Chidswell Housing Development proposals

Experienced former local authority planning ecologist.
International authority on ancient woodland identification, assessment, and management and on related matters of biodiversity net gain and development compensation.

Summary

Appendix 3 – Ancient Woodland Land, Ancient Woodland Buffers and Offsite BNG

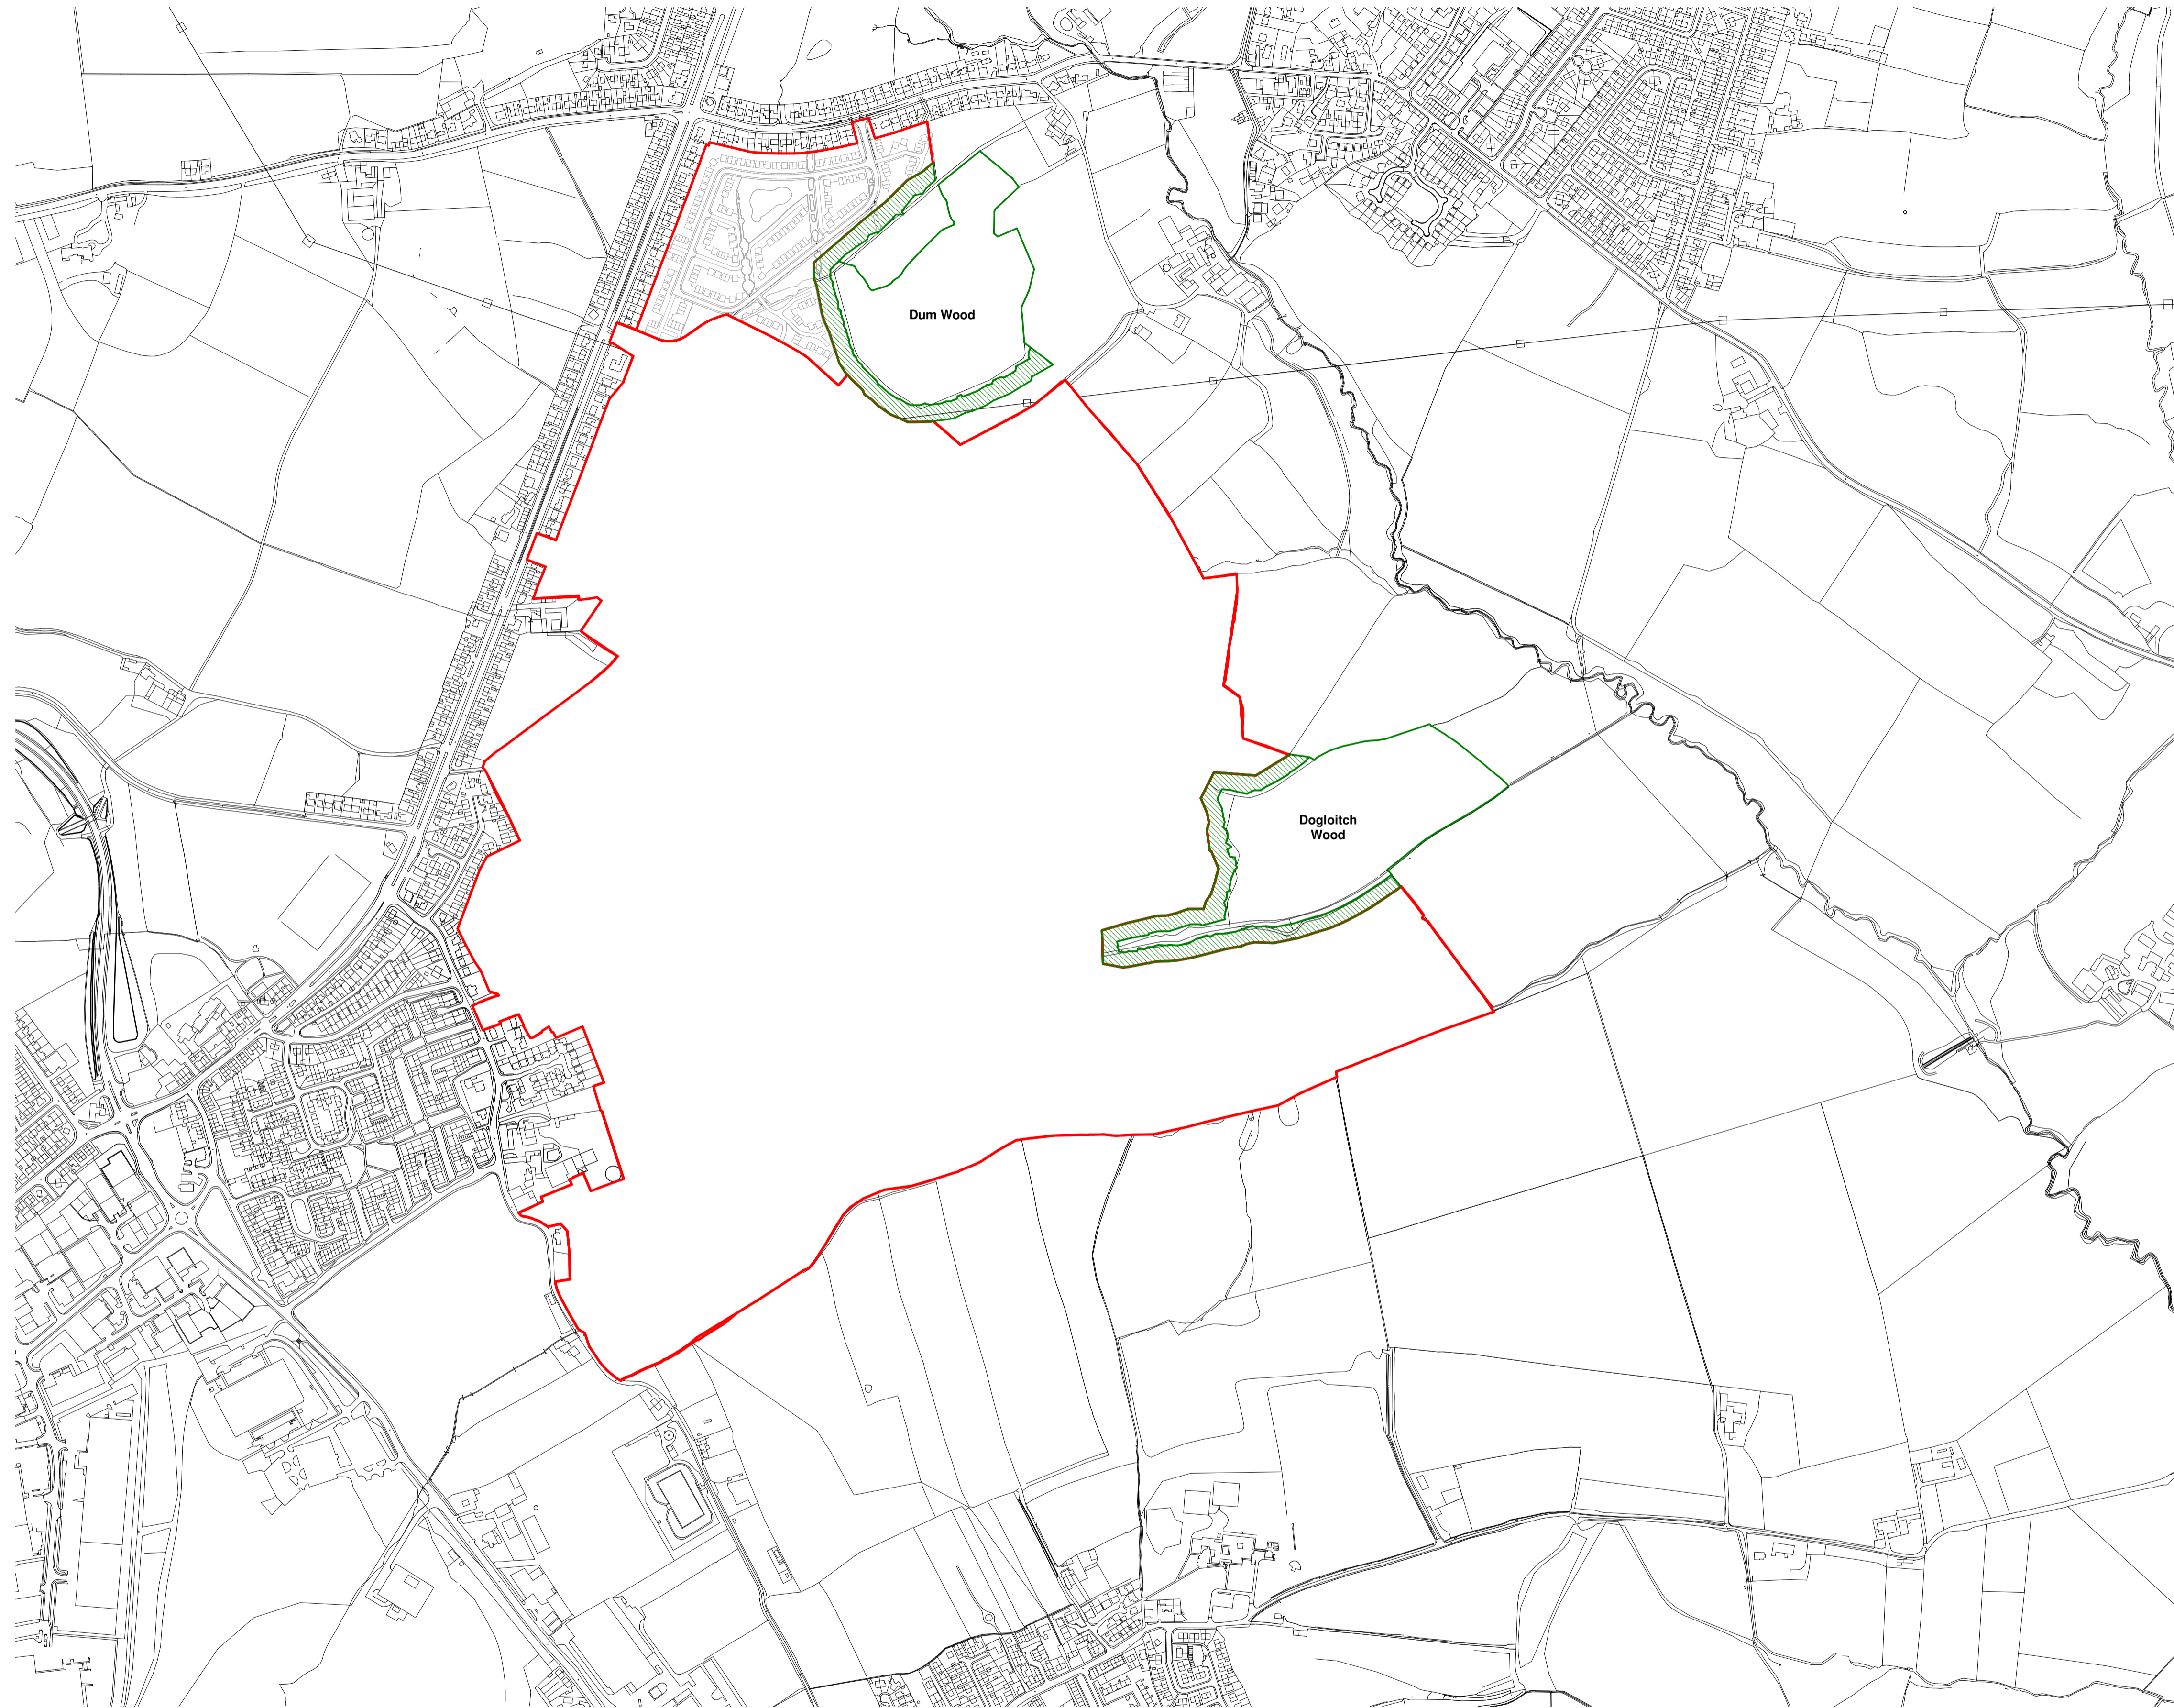
1. Deficiency in addressing direct and indirect impacts and long-term effects on the ancient woodlands.
2. Unnecessary and damaging 'over-management' of trees in part relating to changed health and safety considerations.

3. Consequent isolation and hydrological impacts on the woods with resulting long-term desiccation. There are also issues of impacts on downstream flood-risk which are still to be addressed.

In terms of the woodlands, there has been no effective assessment of woodland heritage and archaeology which are highly vulnerable to trampling and erosion linked to recreational over-use. This requires to be addressed and a funded remediation plan put in place.

There is also an issue in terms of proposals for Biodiversity Net Gain (BNG). Firstly, irreplaceable features such as ancient woodlands and historic hedgerows, cannot be compensated for or traded. Moreover, ancient woodland cannot be used for BNG compensation – which must be targeted at lands of minimal existing biodiversity value.

Either on-site or off-site, BNG cannot be produced through the use of areas of existing high value. Furthermore, it should be noted that BNG does not address landscape and heritage issues but only those purely of biodiversity. From a sustainability perspective, these other factors must also be addressed.
